# CITY OF ALBUQUERQUE

**Re: Parkside Child Development, 901 86<sup>th</sup> st.**  
**Request for Permanent C.O. –Accepted**  
**Engineer's Stamp dated: 9-27-11, (L09/D041)**  
**Certification dated: 7-22-13**

**Re: Parkside Child Development Center  
Grading and Drainage Plan  
Engineer's Stamp dated 9-27-11 (L009/D041)**

# GRADING & DRAINAGE PLAN

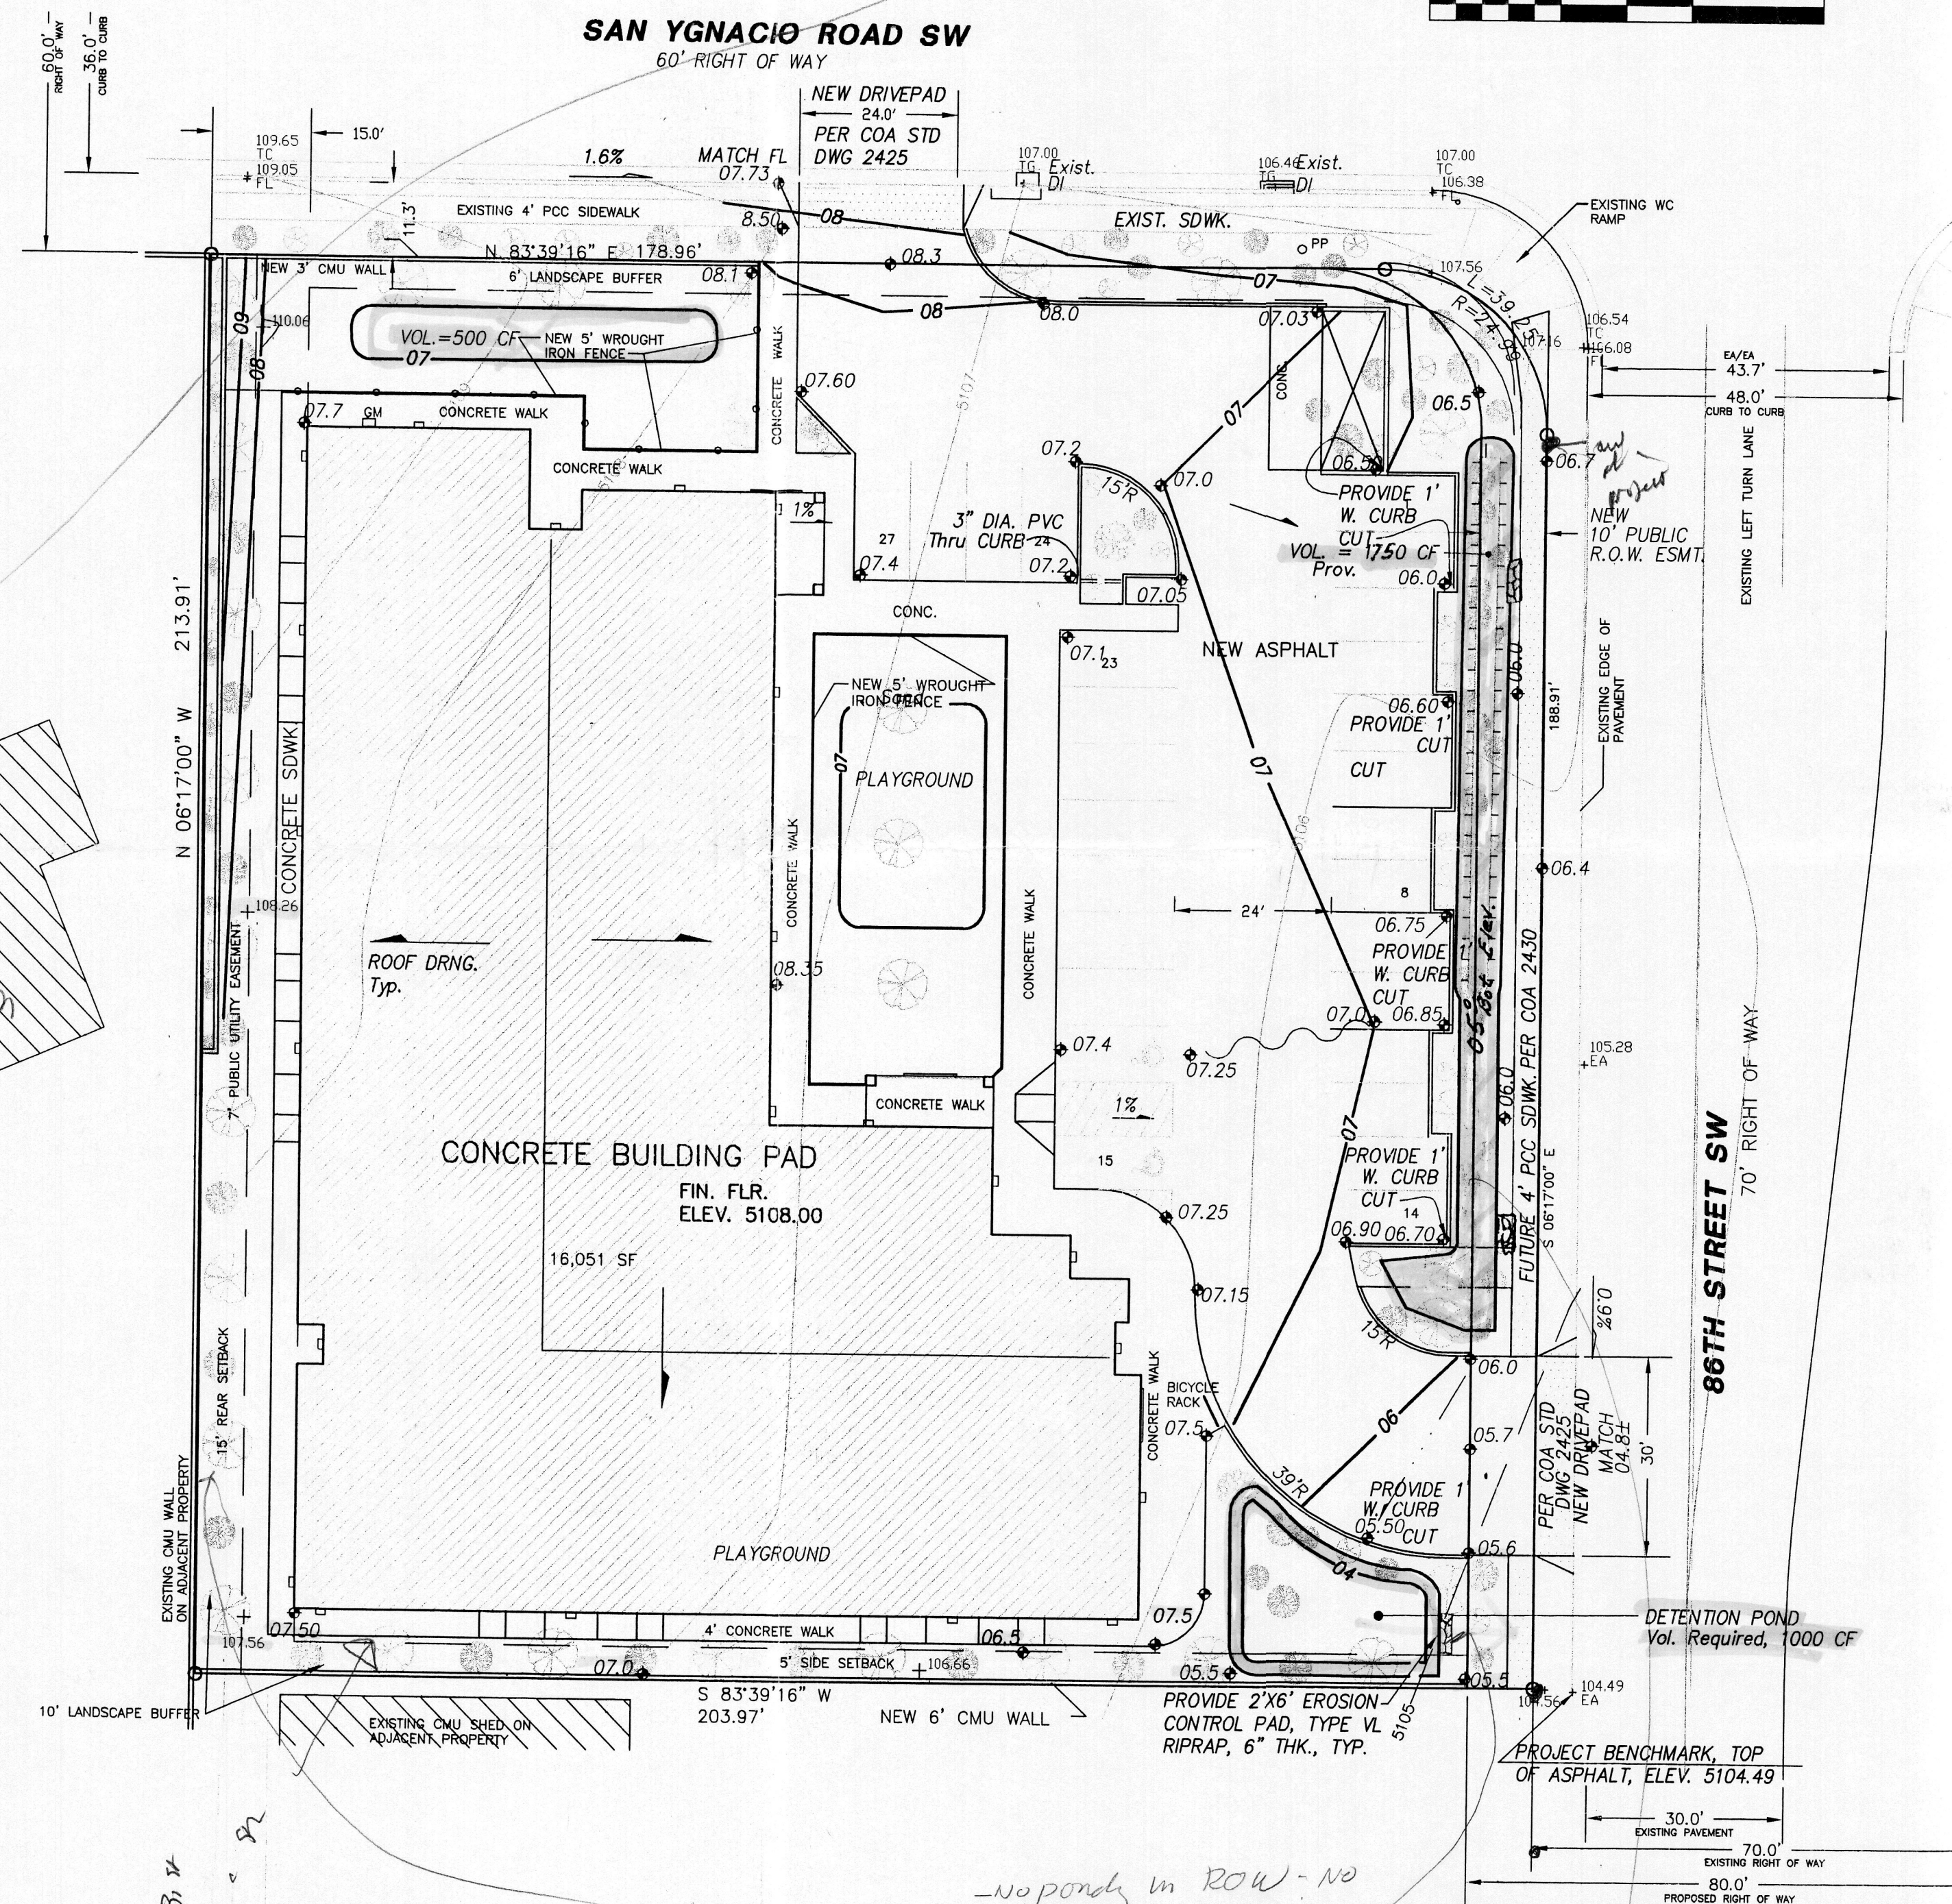
- Ponding will not be allowed within COA ROW. Please adjust drainage scheme to reflect ponding outside of COA ROW.
- Explain why you are ponding instead of directing flows out through driveways?
- You'll need to provide a swale for the West and South segment of property adjacent to CMU walls.
- The detention pond (1000 cf) fronting 86<sup>th</sup> Street will be spilling over the future sidewalk. This will not be allowed. Please provide an alternative design.
- Please remove all statements that aren't applicable to this project. Especially statements concerning Bernalillo County drainage information and historic flows draining through property (proposed and existing wall have changed these flows).
- Usually, Grading and Drainage Plans are good for one year. Please provide a more recent Engineering Stamp date than 01/31/08.

# GRADING & DRAINAGE PLAN

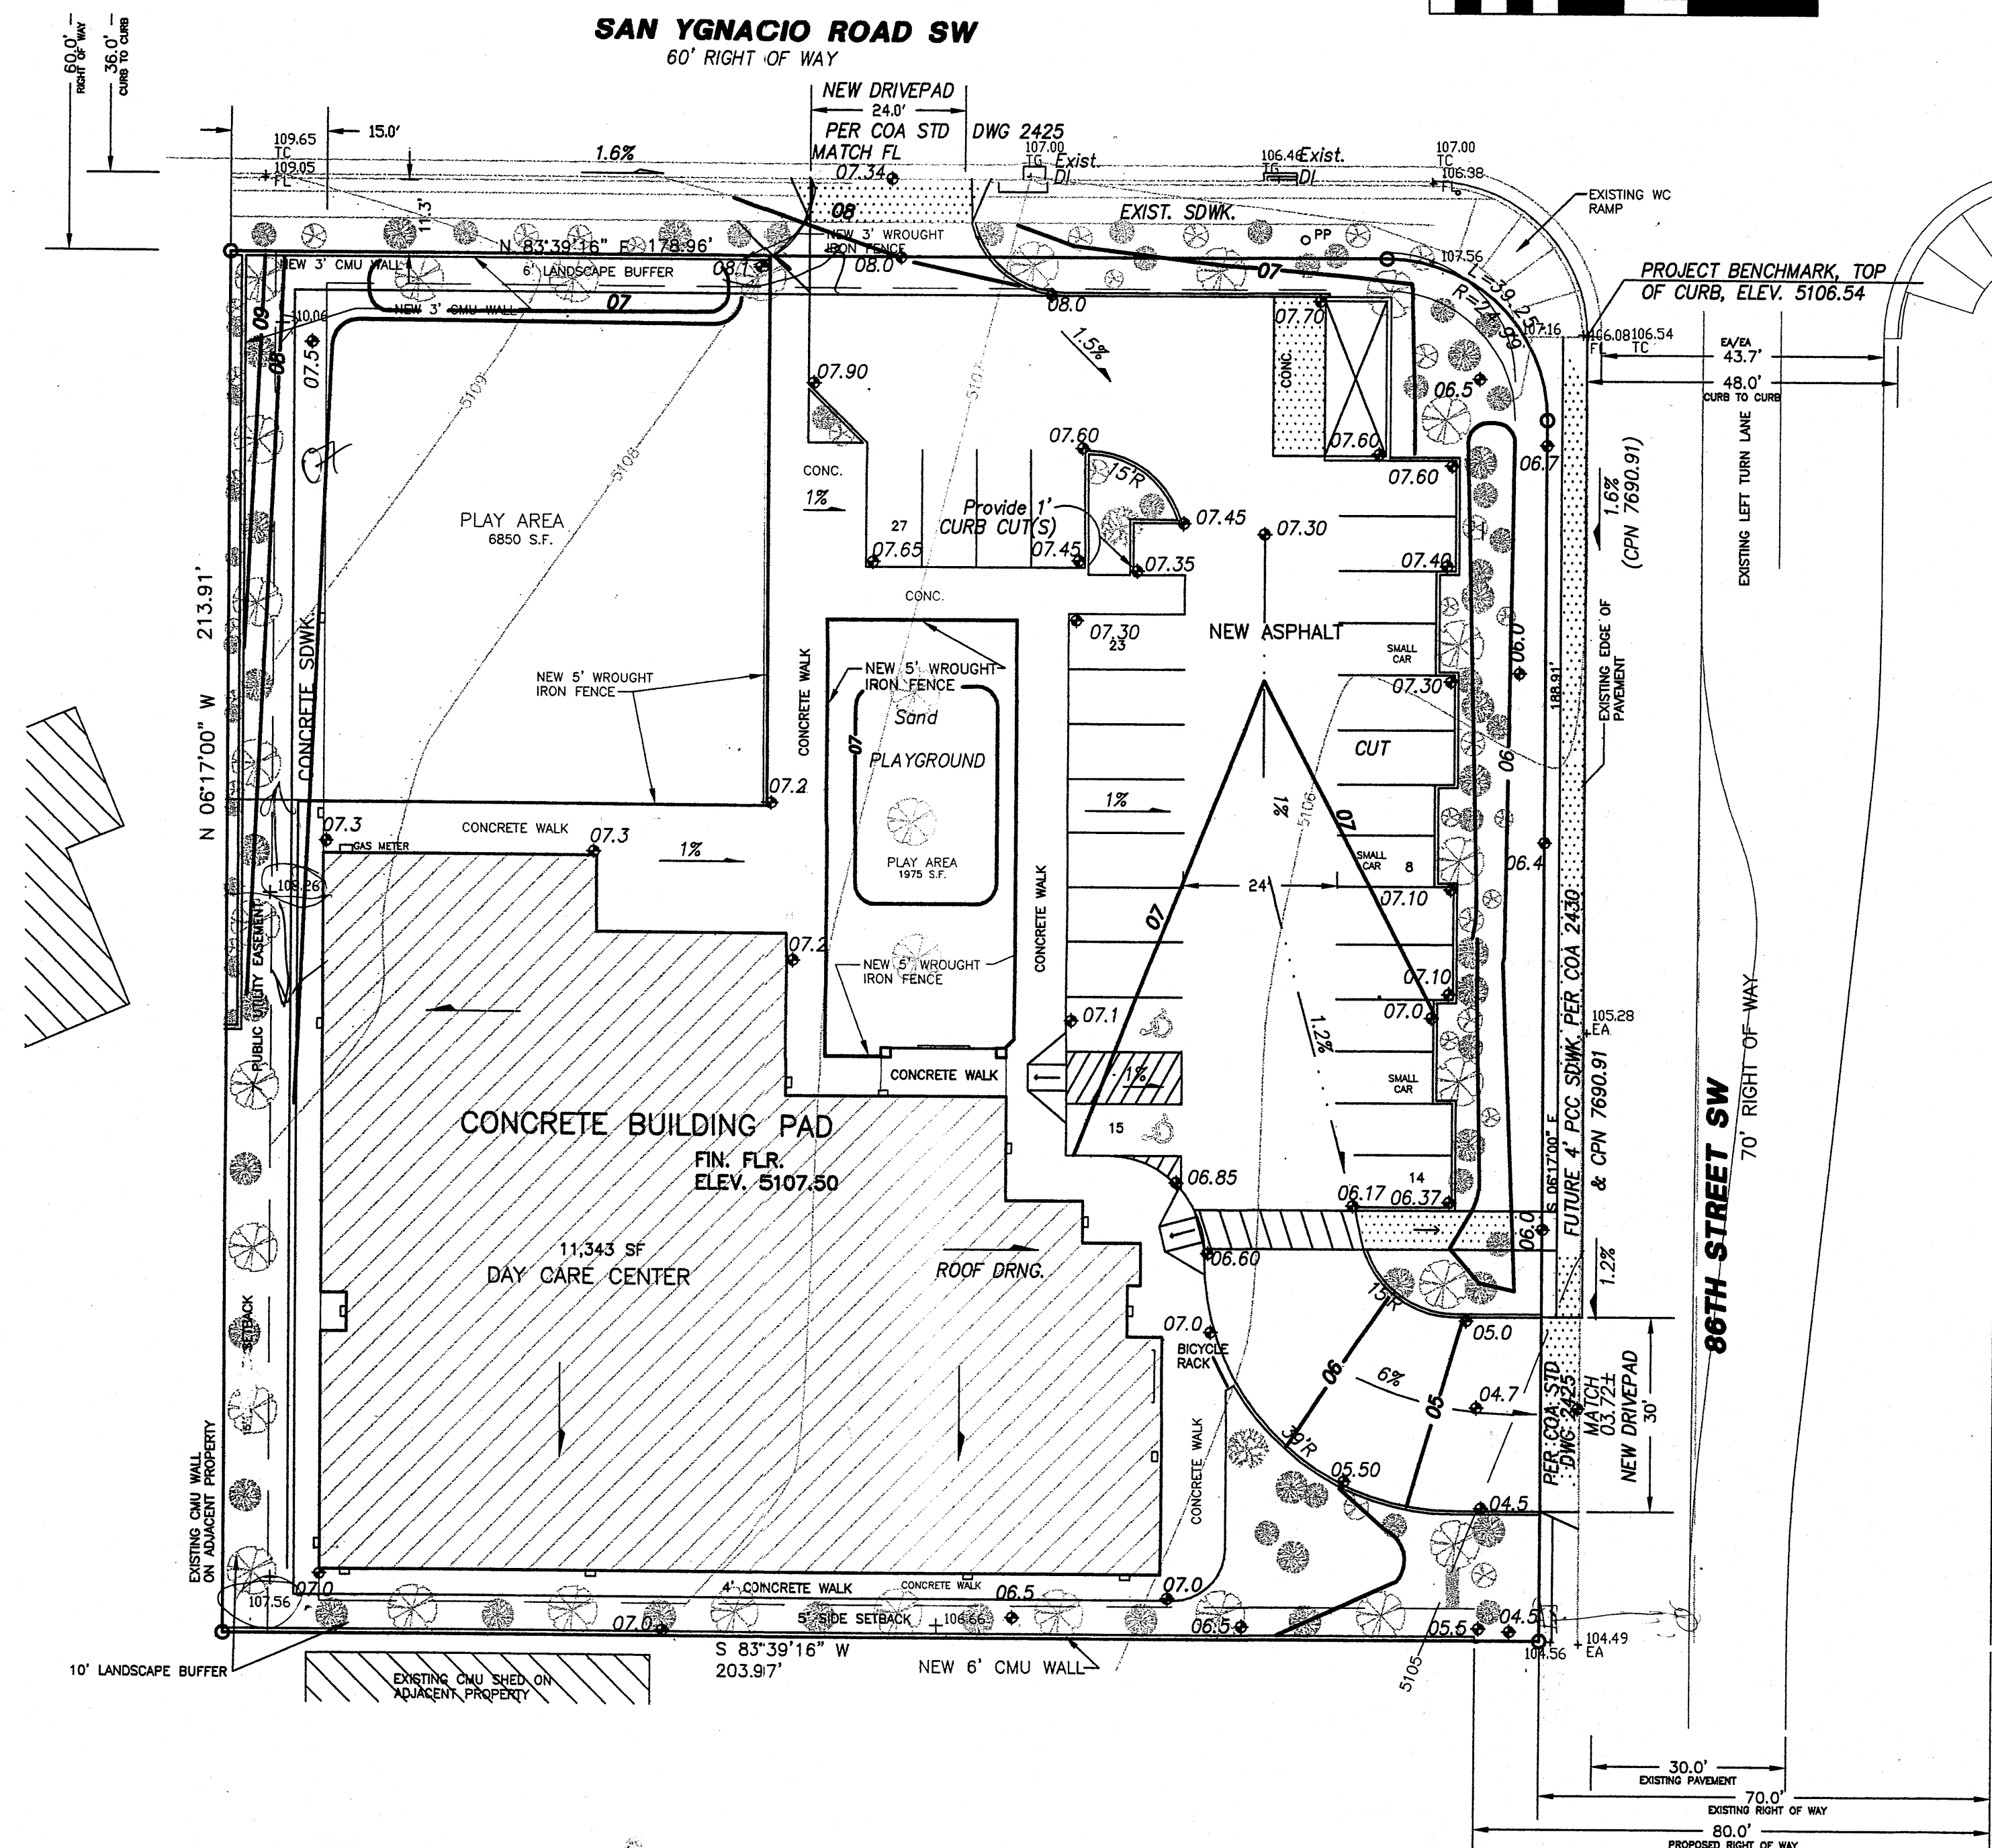
- How will the flows in the landscaped areas exit?
- Depress all landscaping to retain the moisture which falls on them.
- A Five thousand dollar (\$5000.00) payment to DMD for the installation of a new inlet on the corner of 86<sup>th</sup> St. and Sage Rd. per Curtis Cherne, PE Principal Engineer.
- Show spot elevations along 86<sup>th</sup> St from City Project 7690.91.

- How will the flows in the landscaped areas exit?
- Depress all landscaping to retain the moisture which falls on them.
- Show spot elevations along 86<sup>th</sup> St from City Project 7690.91.
